**From:** Jordan Bovee <jordan.bovee.hsy@colvilletribes.com>  
**Sent:** Thursday, October 9, 2025 9:14 AM  
**To:** Ellie Myers; SEPA@dahp.wa.gov; Guy Moura  
**Cc:** JOHN Sirois; Karen Capuder; Shalena Bent; Darnell Sam; Milton Davis; Kiana Sam  
**Subject:** Re: SD-25-00001 Easton Research and Rearing Facility Outfall - Notice of Application

We have completed our review of the SD-25-00001 Easton Research and Rearing Facility Outfall Application.

Attachment 1. Site Plan

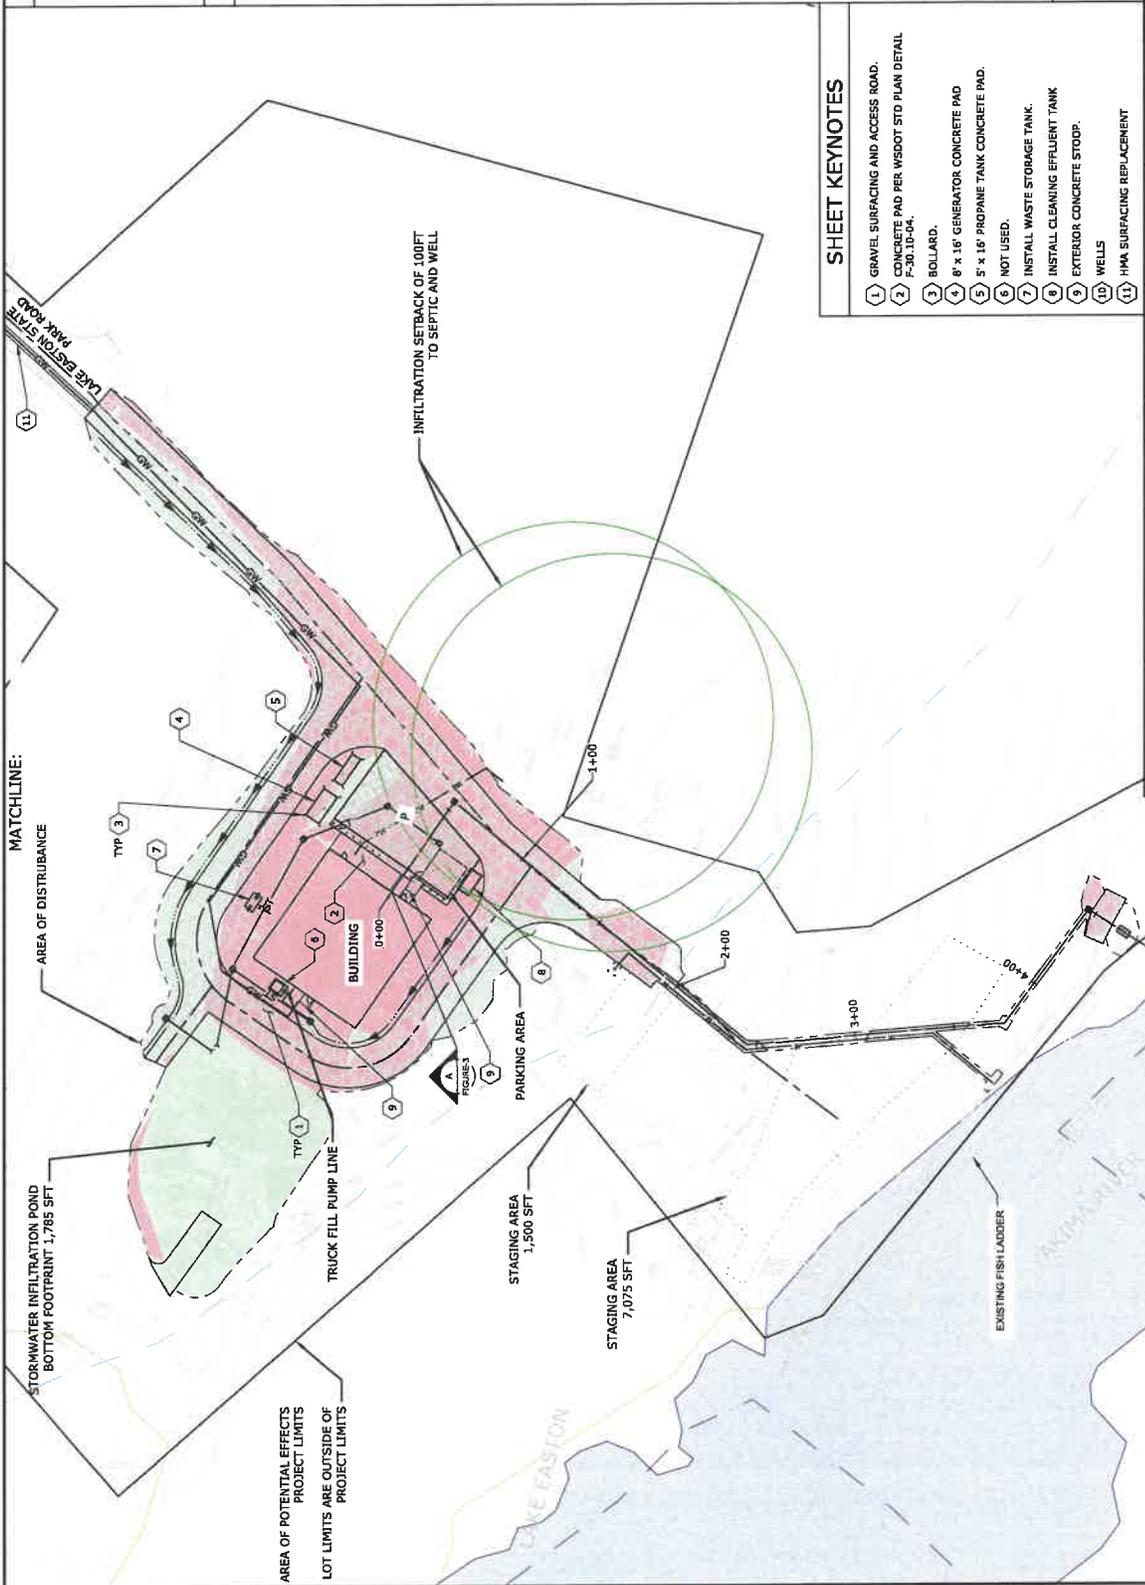
The project application states that no work is proposed in or near historic or cultural sites, however, as shown by the provided site maps the project area is proposed within 500ft or less of several known archaeological sites, of which at least two have been determined to be eligible or potentially eligible for inclusion on the National Register of Historic Places (NRHP). In fact, the site boundaries of at least one NRHP eligible site appear to be partially within the APE of the project based on the provided site plans.

Given the extent of the proposed ground disturbance, which includes the placement of a more than 4,000 square foot facility on a concrete slab at grade, a 2,800 square foot parking lot, and the placement of several new wells and water lines, the CTCR does not concur with the level of effort to identify this project's potential impacts to historic properties and requests more information about the proposed project, including, ideally, a GIS shapefile showing the undertaking's APE and location of proposed facilities for reference. We would also insist that the proponent develop and have on site an Inadvertent Discovery Plan for all project undertakings as well as hire a cultural resources monitor for all ground disturbing activities. Should any cultural material be identified over the course of this project, the CTCR would also request that we are informed and provided with copies of any subsequent reporting related to these discoveries.
